CITY OF ALBUQUERQUE

October 10, 2017

**RE: Solar Villa Apts Remodel
Grading and Drainage Plan
Engineer's Stamp Date 9/19/17
Hydrology File: J19D086**

GRADING AND DRAINAGE PLAN

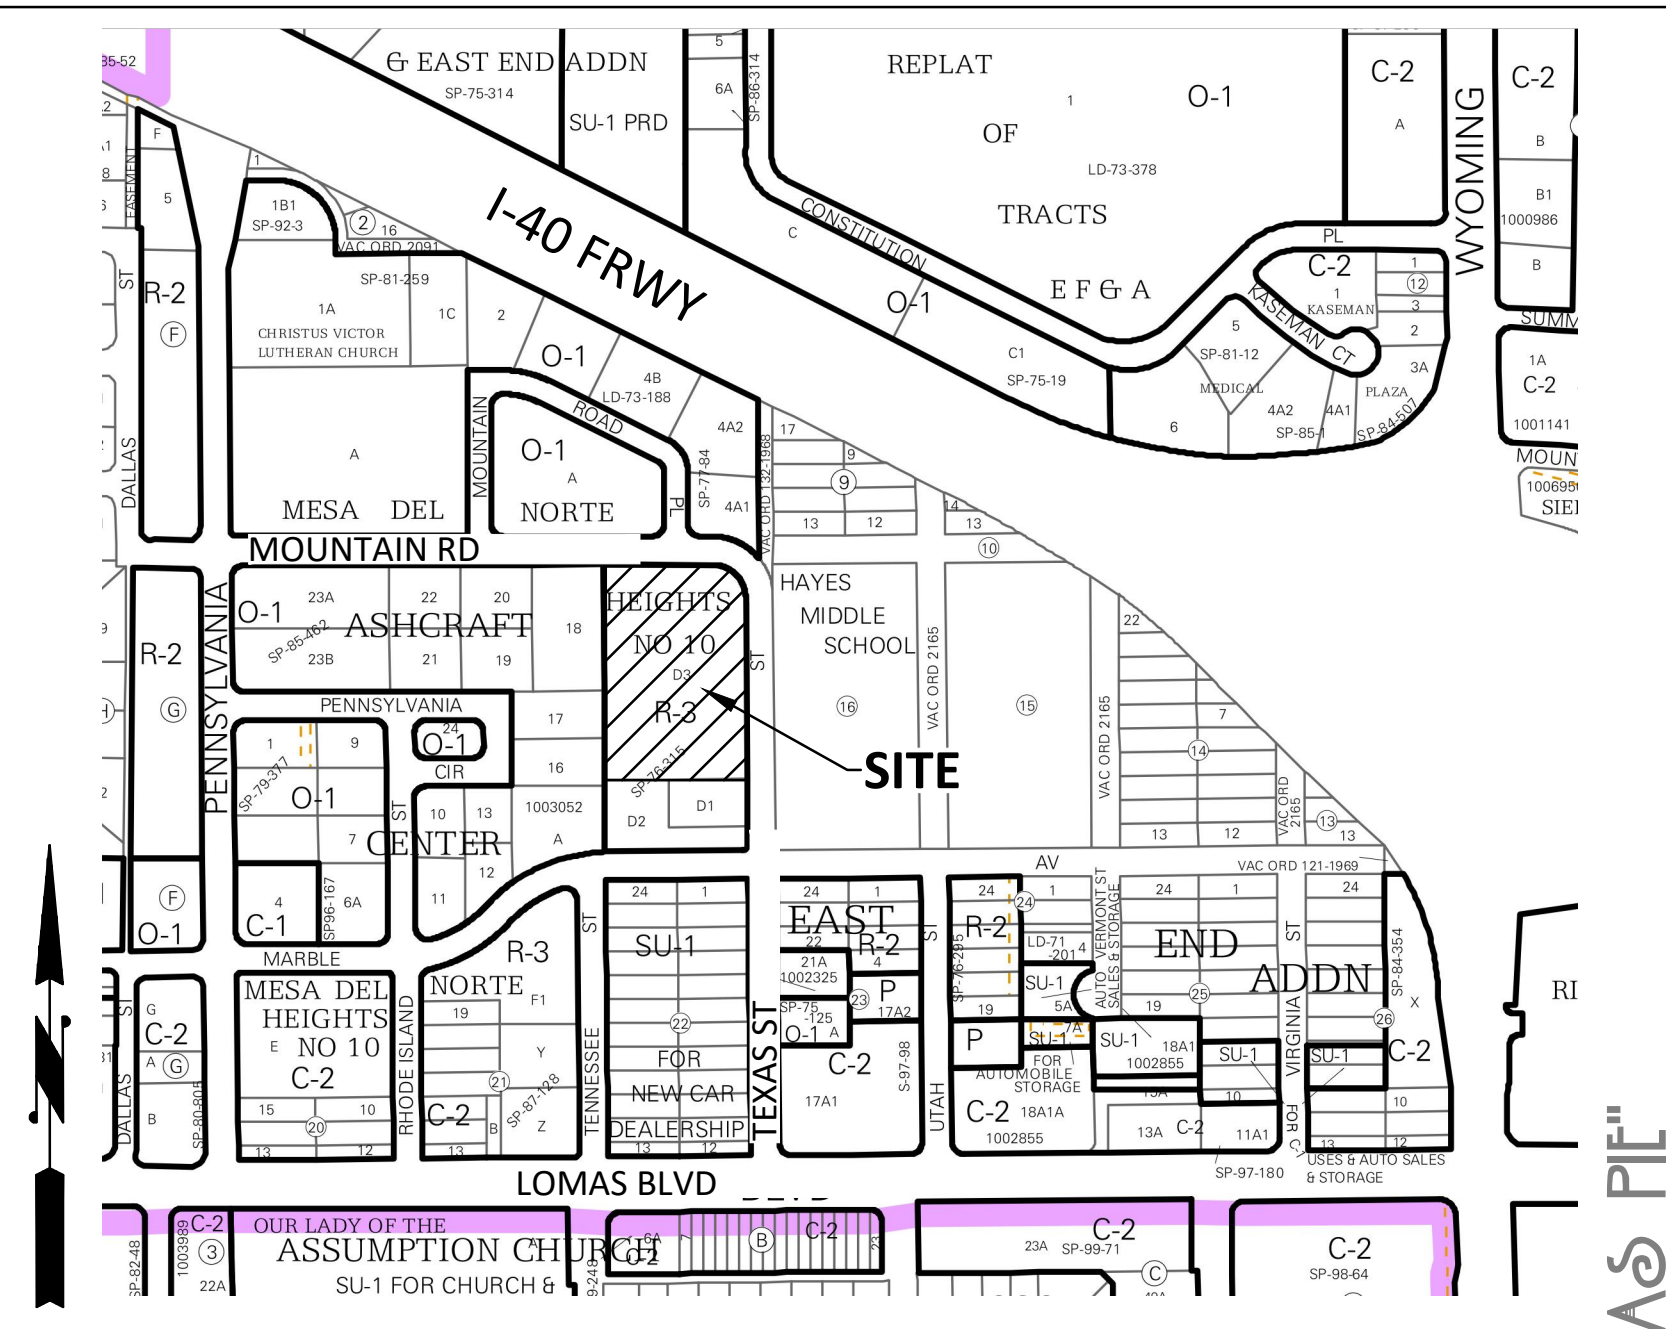
1. SO-19 Notes have been updated. Please see attached and include on plans.
2. A Private Facility Drainage Covenant is required for the first flush ponds. The original notarized form, pond exhibit, and recording fee (\$25 payable to City of Albuquerque) must be turned into DRC (4th, Plaza del Sol) for routing. Please contact Charlotte LaBadie (clabadie@cabq.gov, 924-3996) or Madeline Carruthers (mtafoya@cabq.gov, 924-3997) regarding the routing and recording process for covenants.
